340 PARKDALE

Podium Massing Refinement

Response to OPA + ZBLA Comments

SOUTH ELEVATION

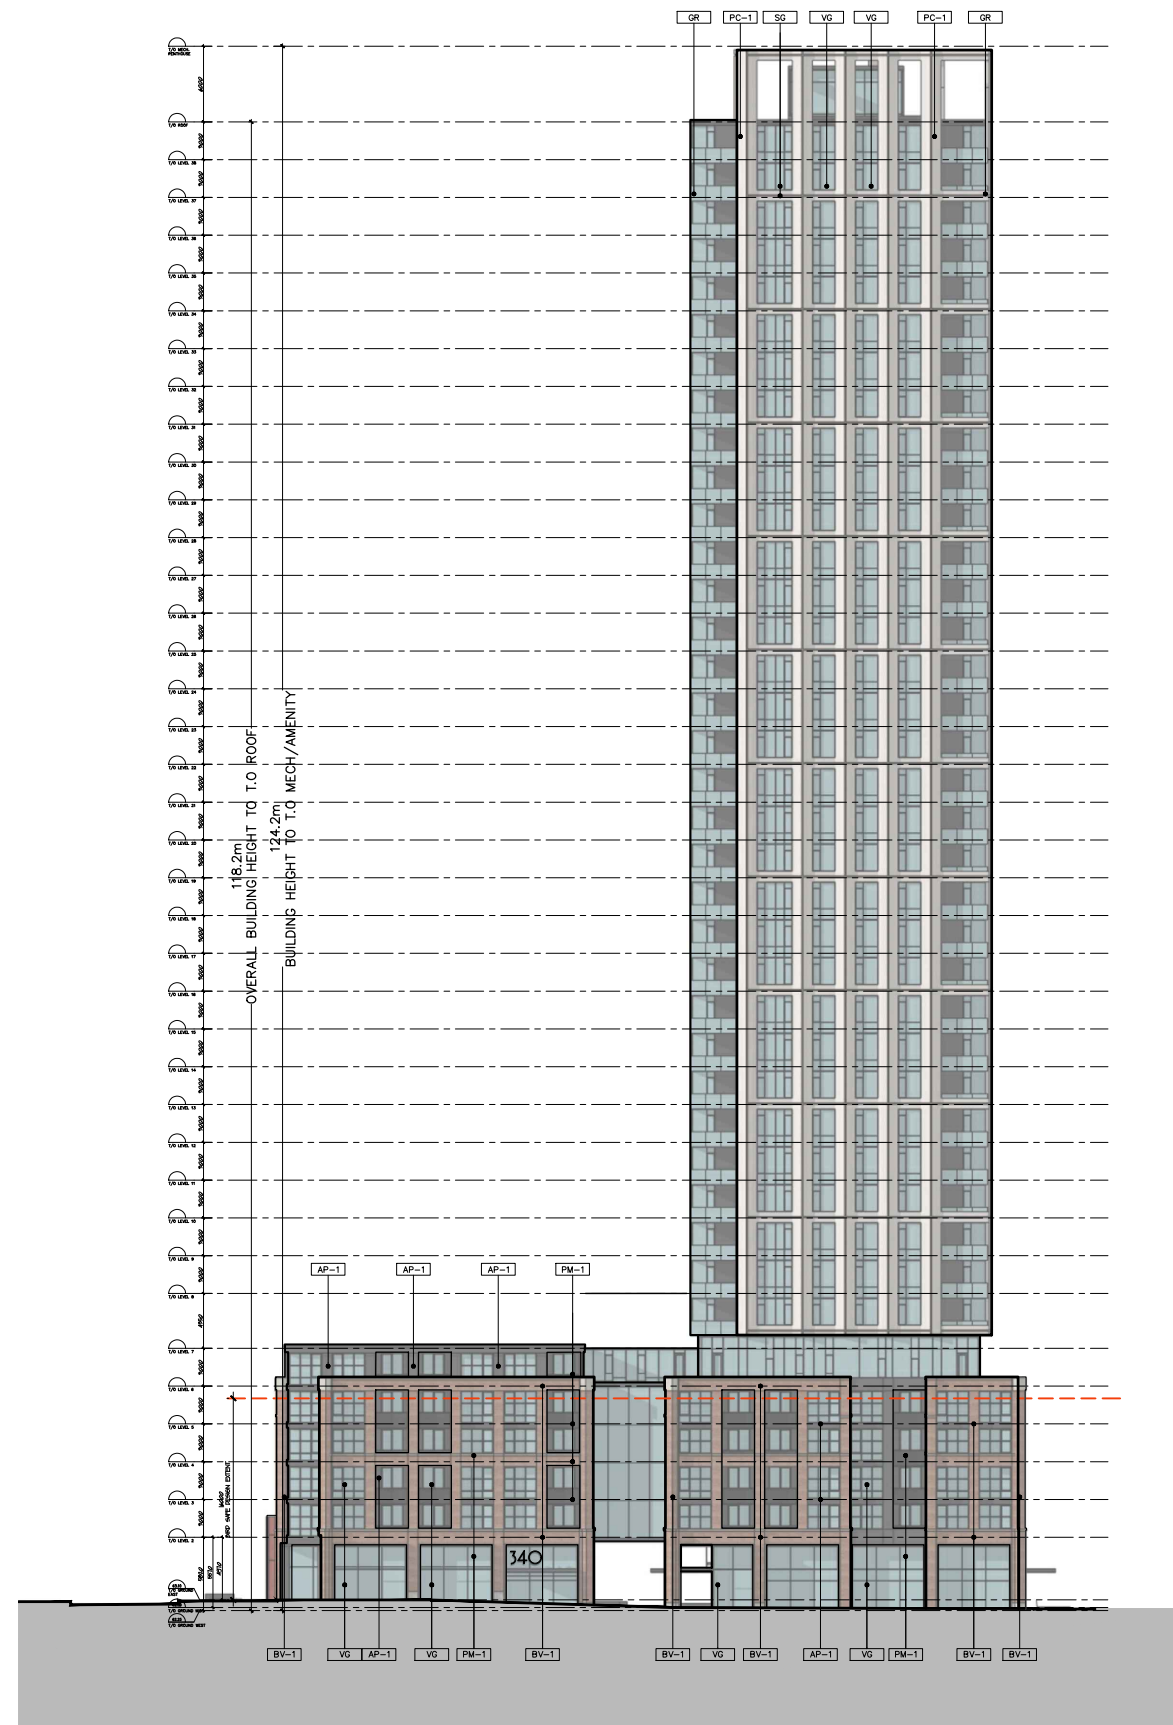
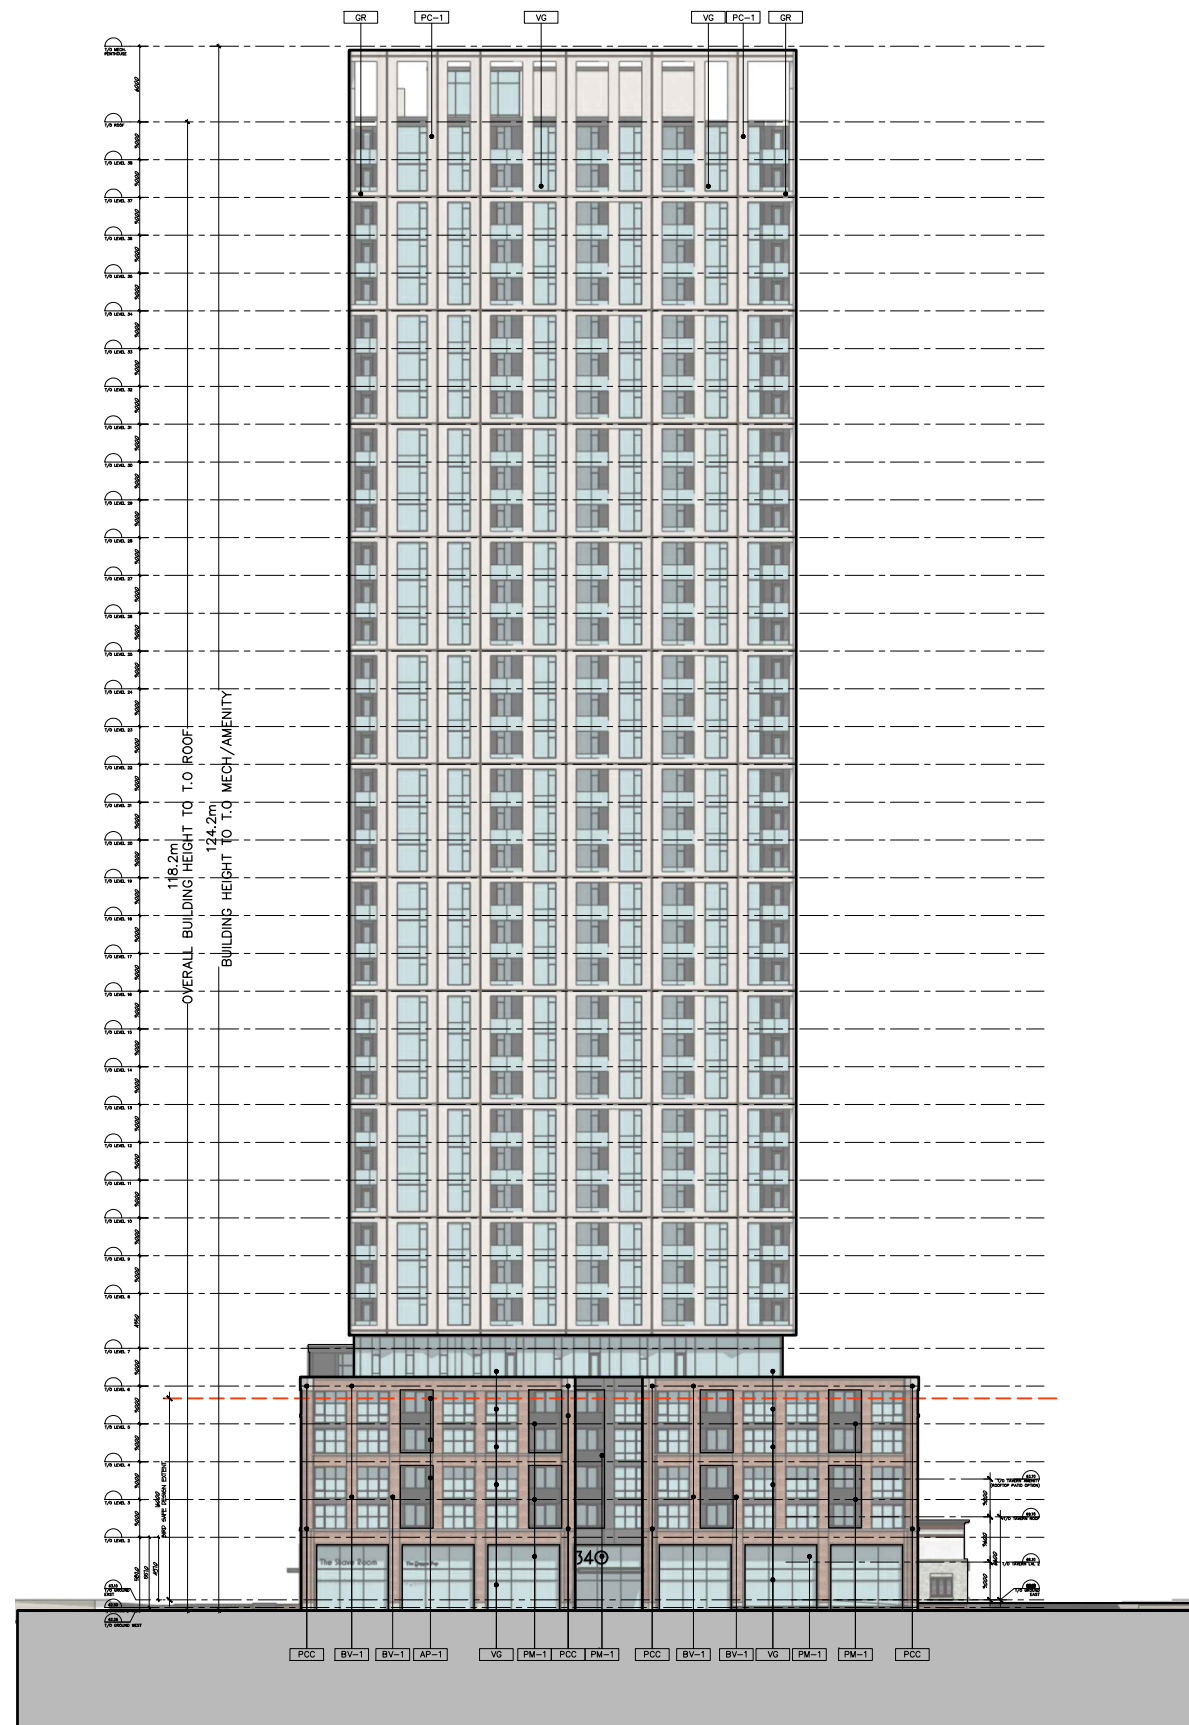
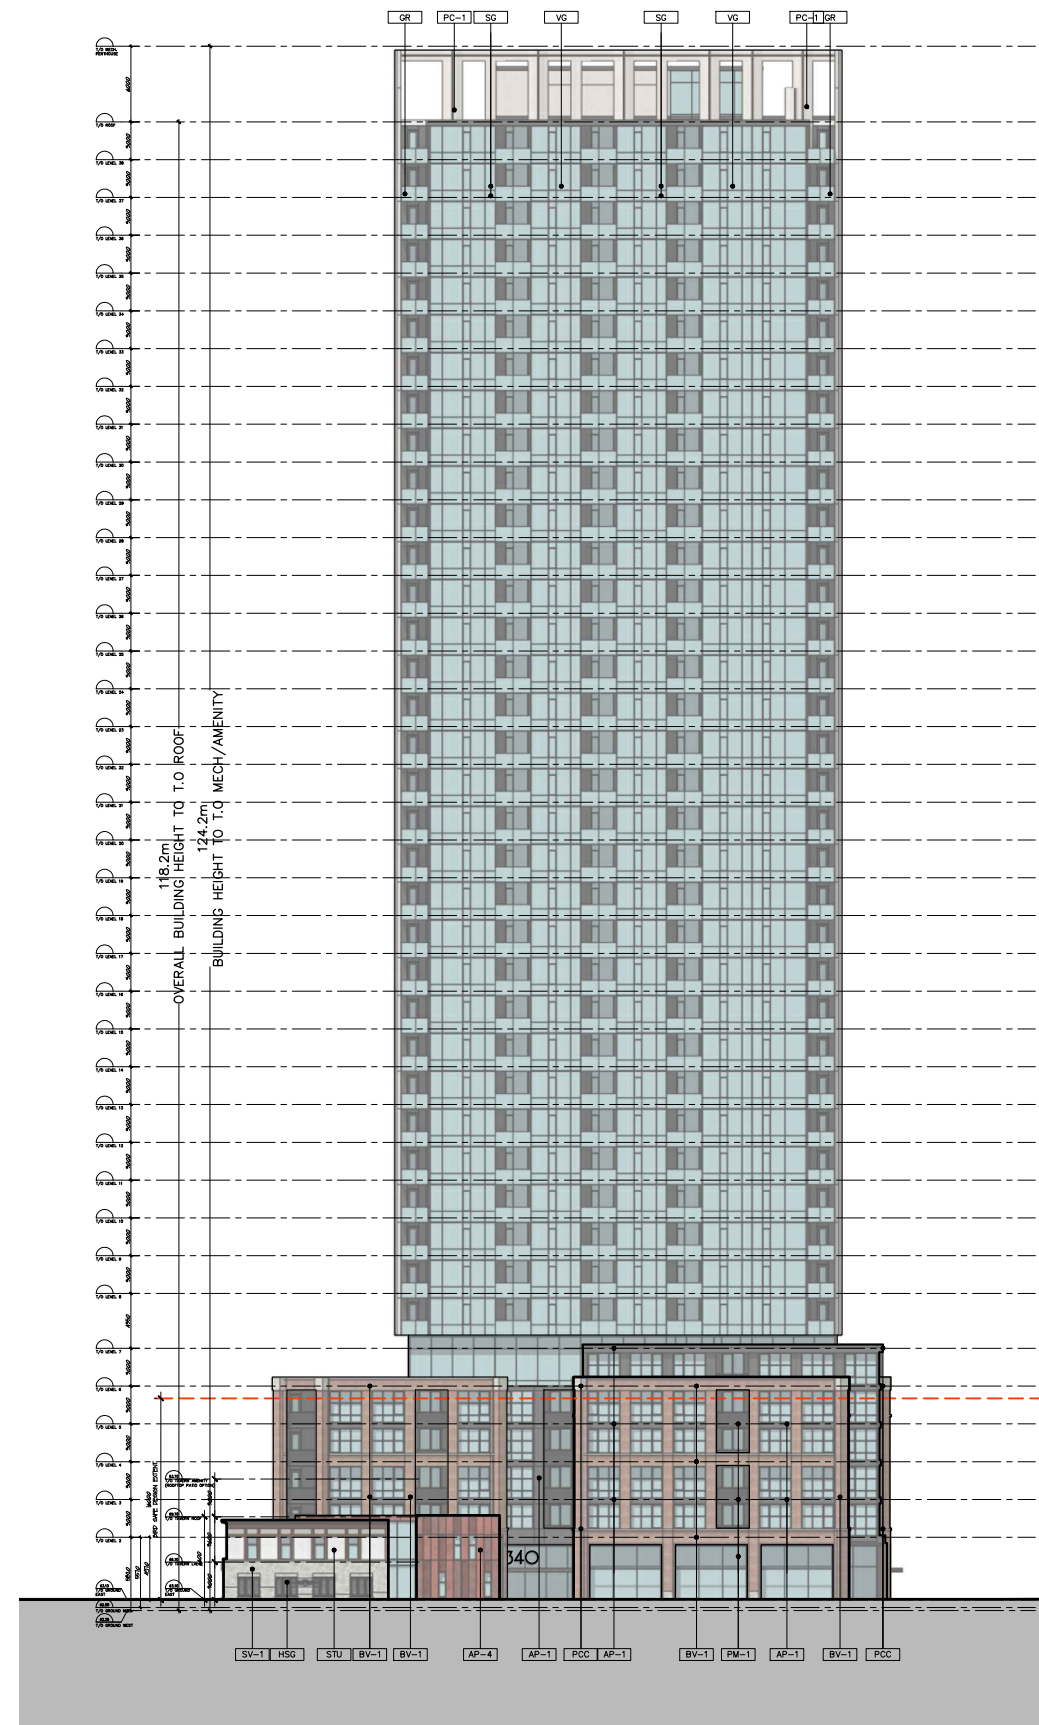
In response to City comments regarding podium scale, massing transition, and the pedestrian experience along the surrounding streets, the podium has undergone a significant redesign intended to reduce its perceived scale and establish a stronger relationship with the surrounding neighbourhood context. The revised approach focuses on reducing overall height, improving the pedestrian experience, and breaking down the podium into a series of smaller, more contextual building components.

The most significant change is the removal of the two-storey “pop-up” volume previously located along the Parkdale Avenue frontage. In the earlier iteration of the design, this upper volume contained two-storey residential units and introduced additional height and visual complexity along the podium edge. This element has now been entirely removed and replaced with a more consistent arrangement of typical residential units. As a result, the eastern podium wing has been reduced from eight storeys to six storeys, while the overall podium height has been lowered by two full storeys.

This change will read as a downward transition from the 8-storey mass on the property to the north to the 6-storey podium, two storey re-imagined tavern, and then Armstrong Street and Parkdale Park and Public Market to the south.

Along Armstrong Street, Hamilton Street, and Spencer Street, the western half of the podium beneath the tower has also been reduced by one additional storey and is now five storeys in height. This reduction results in a substantially lower and more human-scaled streetwall condition. Facing Armstrong Street and the Parkdale Market, the revised five-storey mass establishes a scale that is more compatible with the surrounding neighbourhood fabric and reinforces a stronger pedestrian relationship with the public realm. The lower streetwall creates a more comfortable sense of enclosure and better aligns with the intent of the Official Plan's emphasis on pedestrian-oriented design, transition, and contextual fit within Inner Urban areas.

A strong visual datum has also been introduced through the extension of the red heritage-inspired brick façade up to the fifth level around the podium. This consistent horizontal expression establishes a clear streetwall scale, visually anchors the building to the surrounding context, and reinforces the podium base as a cohesive element. The datum line helps establish a stronger relationship to adjacent buildings while creating a more pedestrian-scaled reading of the mass.

Along Hamilton Street, the podium has been organized into a series of distinct building components while maintaining consistency in the streetwall to align with the character to the west.. A brick mass anchors the Armstrong/Hamilton corner, while a darker industrial aluminum volume at mid-block creates a visual separation and emphasizes the primary residential entrance. A secondary brick volume wraps the Hamilton/Spencer corner and is again separated through darker recessed elements. These breaks create rhythm and variation along the streetscape while reducing the perceived scale of the overall podium. Together, these design approaches speak to the established character to the immediate north at 45 Spencer.

Along Spencer Street, the building expression is further divided into a series of distinct blocks, giving the impression of multiple smaller buildings rather than a single continuous structure. This approach reflects the existing pattern of development in the area and reinforces the finer-grain urban character currently present on the site and within the surrounding neighbourhood. The eastern Parkdale wing is read as a separate building component and is distinguished through a glazed link element located above the breezeway, creating a visual break between masses and further reducing the apparent scale of the podium.

Collectively, these revisions substantially reduce the overall podium presence and establish a more contextual, pedestrian-oriented built form. By removing a full typical floor and eliminating the upper two-storey box volume, the revised design significantly lowers the perceived and actual height of the podium while improving its relationship to the surrounding streets and public spaces. The result is a podium composition that better fits within the existing neighbourhood fabric and achieves a more comfortable, human-scaled experience at grade while maintaining the broader project objectives for intensification and housing delivery.
